City of Albuquerque Stormwater Construction Site Inspection Report

ESC File No.	E14E002A	Project Name:	Spanish Walk Subdivision		
NPDES Id. No.	NMR1006F1	Location:	410 Camino Espanol NW		
11/5/2024	Owner		Contractor		
Operator	Las Ventanas NM, Inc				
Contact name & title	Andy Woolf				
e-mail	andy@lasventanas.com				
Contact Phone #	505-803-7420				
COA Inspector	Chancellor English		Start/End Time:	2pm	
Construction Phase:	none, weeds and partial land disturbance				
Type of Inspection:	Regular	Storm Event	Post Storm Event >0.25"	311/Complaint	Follow Up
Weather at time of inspection?	Clear		Temperature: ~	60	
Estimated date of last storm 0.25" or greater	11/4/2024

ESC-1

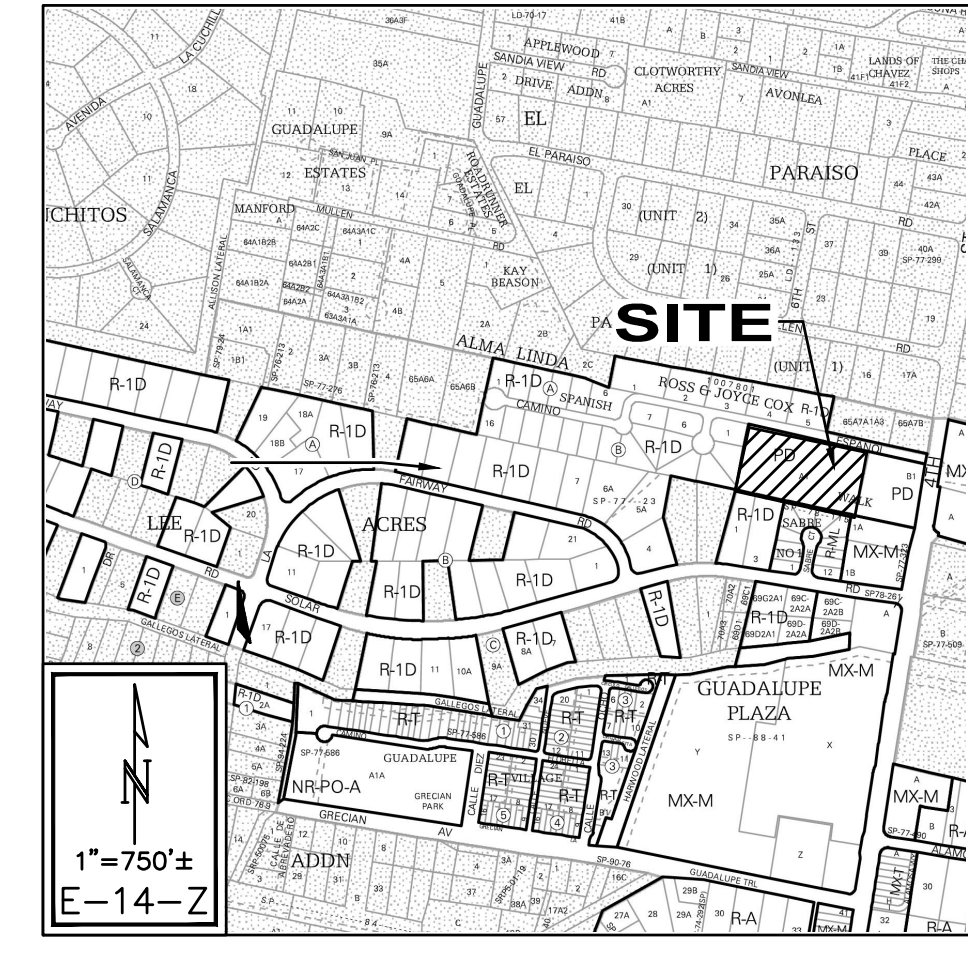
3	The lack of a stabilized construction exit has caused excessive sediment track-out onto Camino Espanol NW in violation of CGP Part 2.2.4. Required mitigation: Minimize sediment track-out by a) restricting vehicle use to properly designated exit points, b) using appropriate stabilization techniques at all points that exit onto paved roads, c) and implementing additional track-out controls as necessary to ensure that sediment removal occurs prior to vehicle exit. Where sediment has been tracked-out from your site onto paved roads, sidewalks, or other paved areas outside of your site, remove the deposited sediment by the end of the same business day in which the track-out occurs, or by the end of the next business day if track-out occurs on a non-business day. Remove the track-out by sweeping, shoveling, or vacuuming these surfaces, or by using other similarly effective means of sediment removal. You are prohibited from hosing or sweeping tracked-out sediment into any constructed or natural site drainage feature, storm drain inlet, or receiving water per CGP Part 2.2.4.
